Address: 2, Reservoir Street, Dewsbury, WF13 4NQ

Application number: 2025/93313	
What is the application for?:	Erection of two storey front extensions with balcony, two storey rear extension,
Address of the site or building:	68, Oxford Road, Dewsbury, WF13 4EH
Postcode:	WF13 4EH

Type of comment: An objection	
Do you wish your comments to be published on the website anonymously?	No
I wish to object to the above application. My property at 2 Reservoir Street, Dewsbury, WF13 4NQ, lies directly to the rear of the application site and would be directly affected by the proposed development. This property has already been substantially extended in 2009/2010 to almost double it's original size which was initially built as a bungalow. 1. Overdevelopment and Lack of Subservience Rebuttal to Planning Statement paragraphs 3.1, 6.1–6.6, 6.29 The Planning Statement acknowledges that the proposed extensions are “large” but concludes they are acceptable due to plot size. This approach fails to assess the cumulative impact of: • A two-storey rear extension • A single-storey rear extension • Multiple balconies • Increased height and bulk across the full rear elevation Policy LP24(c) and the House

Proposed South Elevation - 1:100

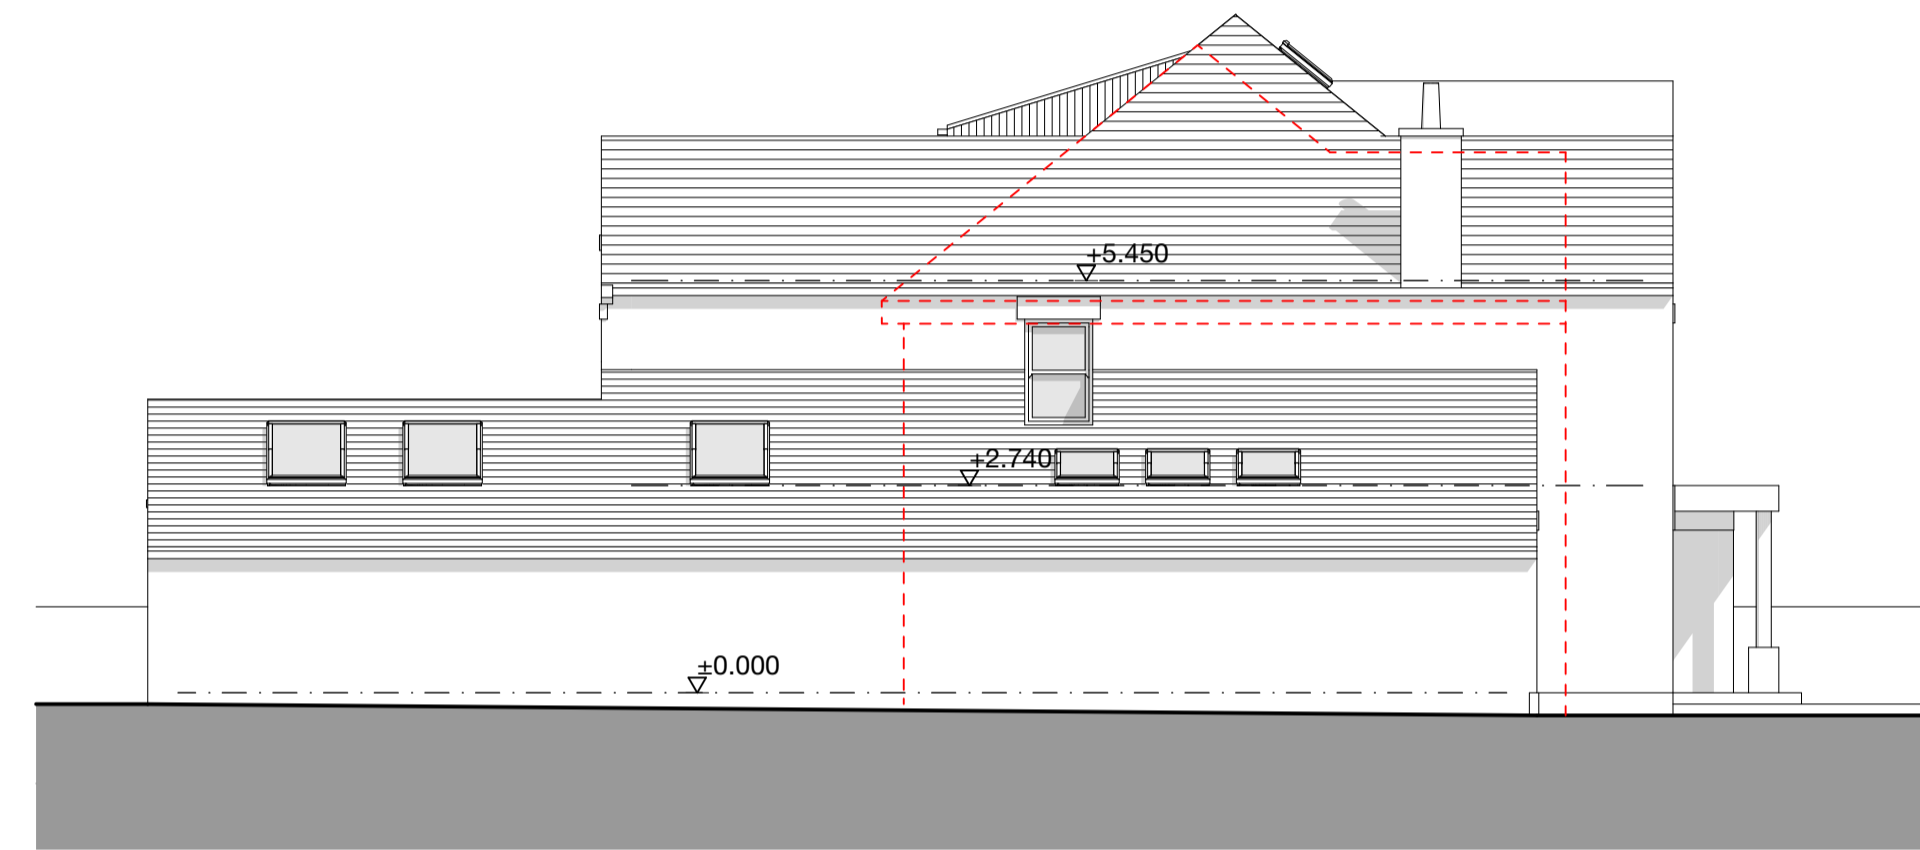
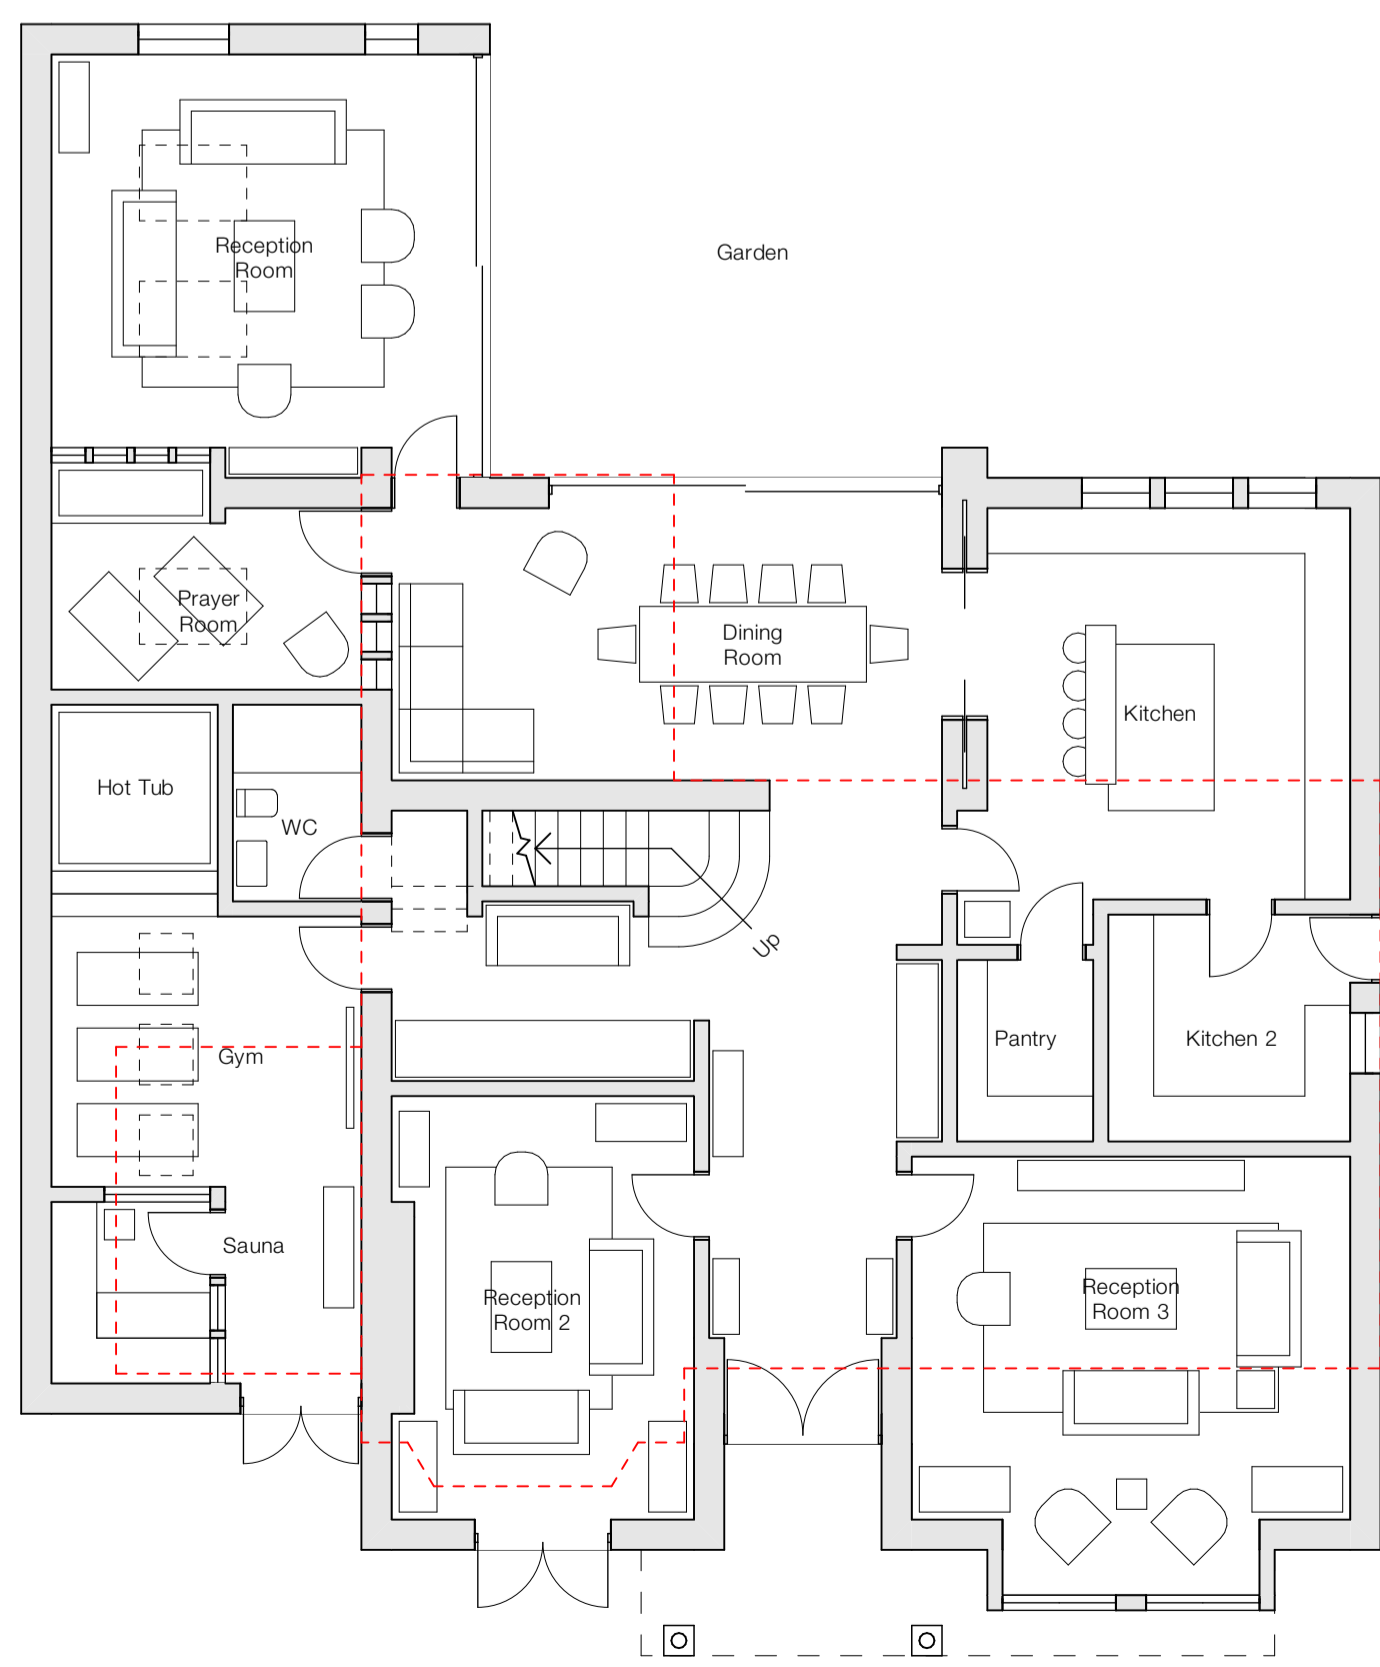
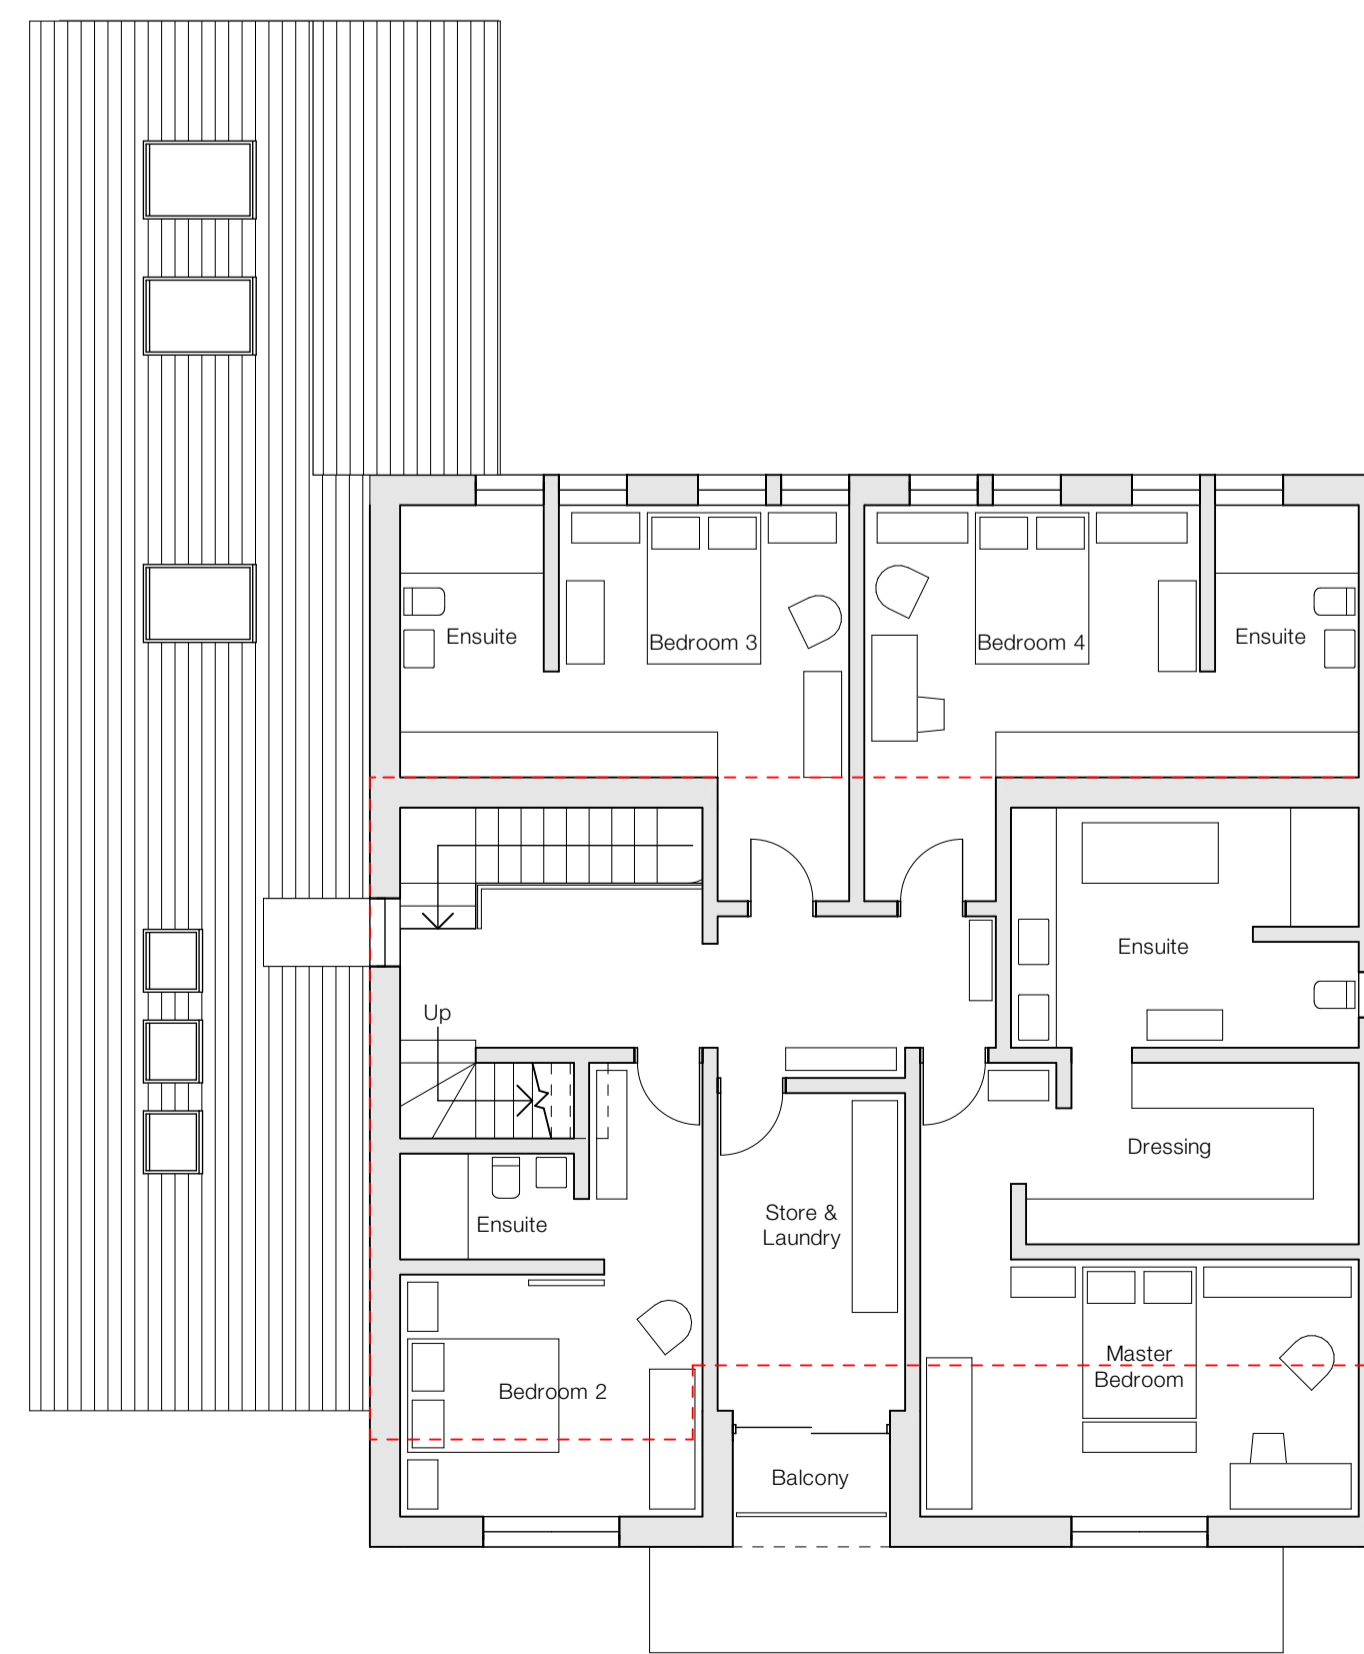
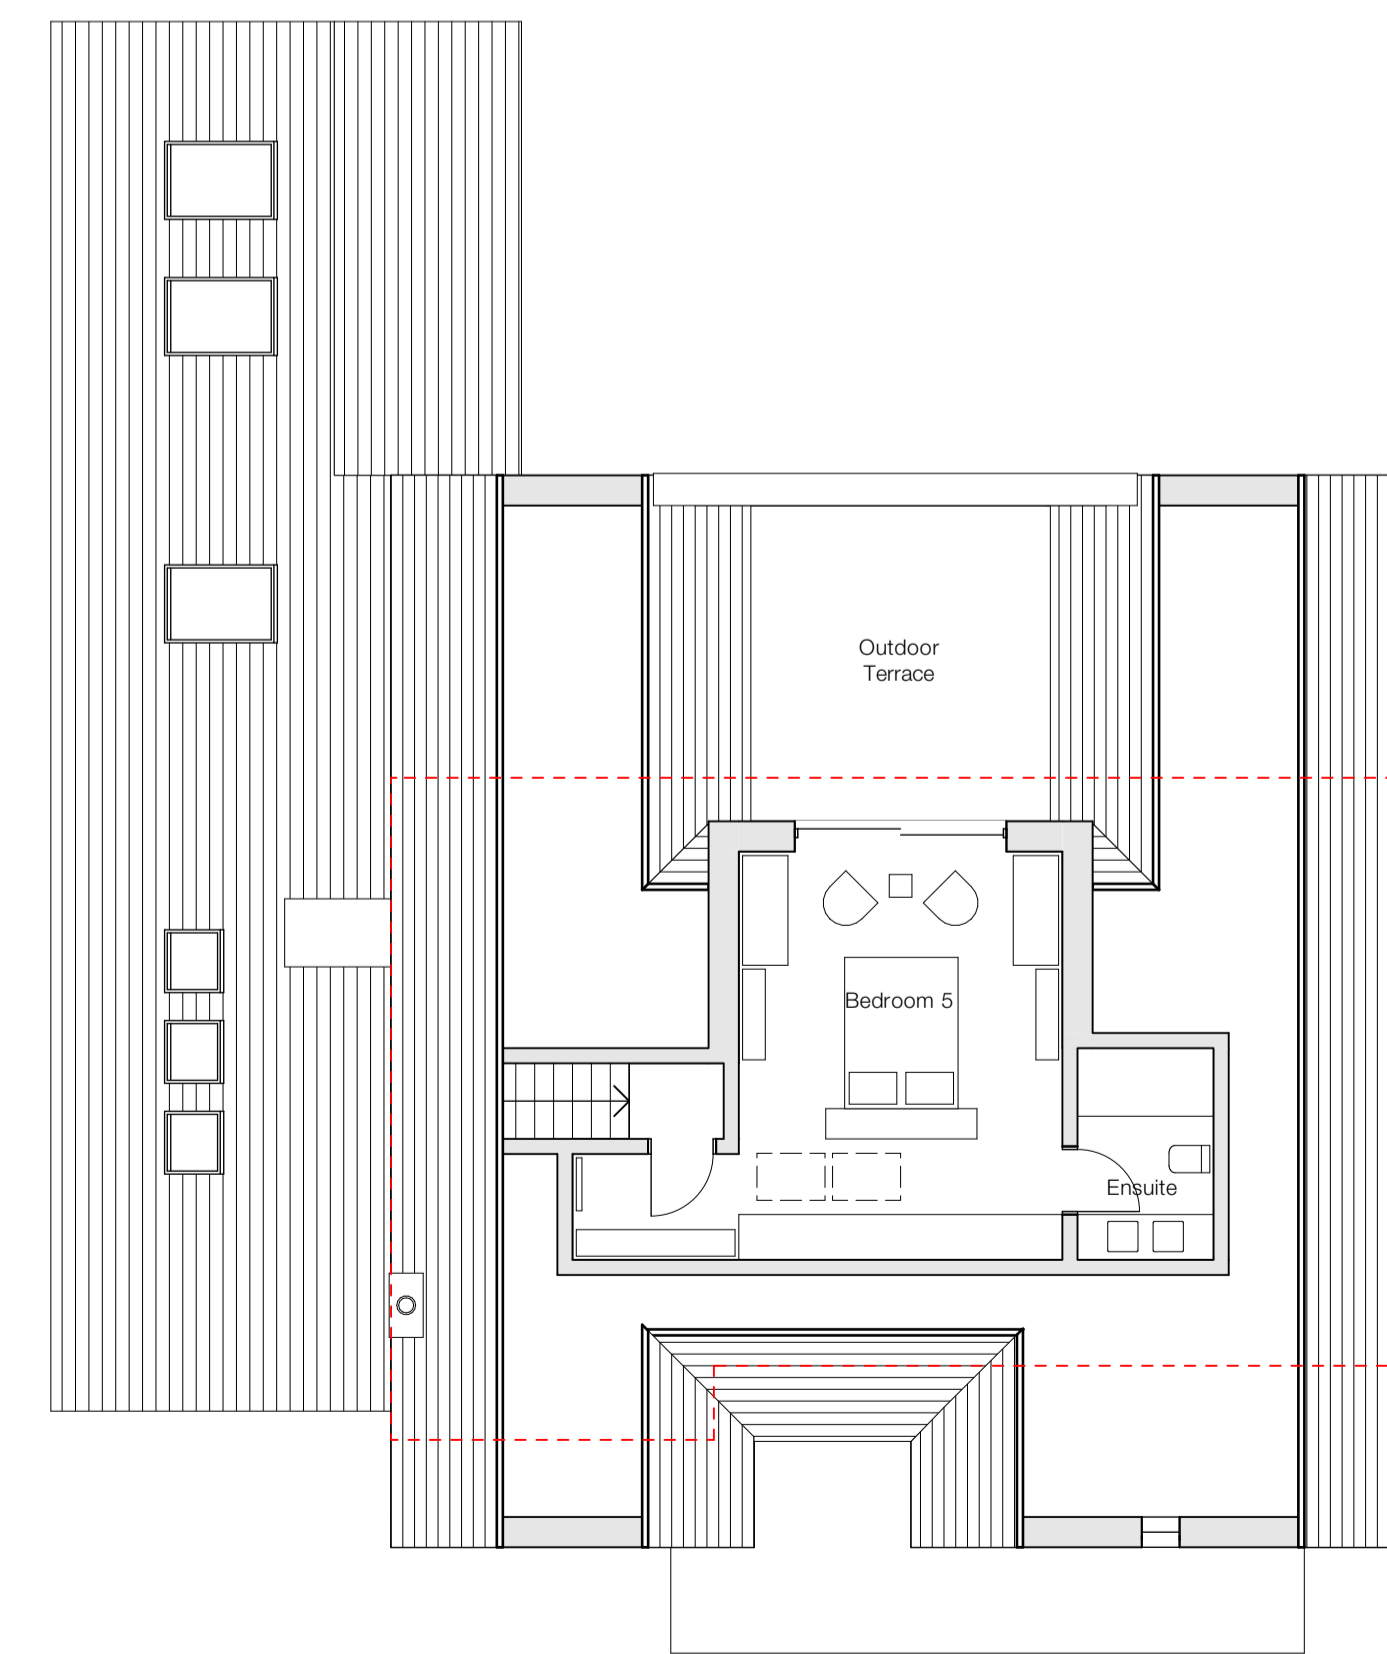
Paragraph 6.15 of the Planning Statement states that views from the balconies would be limited and primarily toward the applicant's own garden. This is incorrect.

The balconies are elevated and rear-facing, and my property at 2 Reservoir Street sits directly behind the site, meaning the proposals would enable direct overlooking into private rear garden space.

No meaningful mitigation (such as obscure screening or balcony redesign) is proposed, and reliance on existing trees is unreliable given seasonal changes.

The Planning Statement concludes that the extensions would not be overbearing due to retained distances and roof design. However, this underestimates the impact of the combined height, depth and mass of the rear extensions when viewed from Reservoir Street.

The cumulative built form would create a dominant rear elevation, resulting in a sense of enclosure and loss of outlook from neighbouring properties, including No. 2 Reservoir Street.

For these reasons, the application should be refused, or substantially redesigned, including the removal of rear-facing balconies and a reduction in rear extension scale.
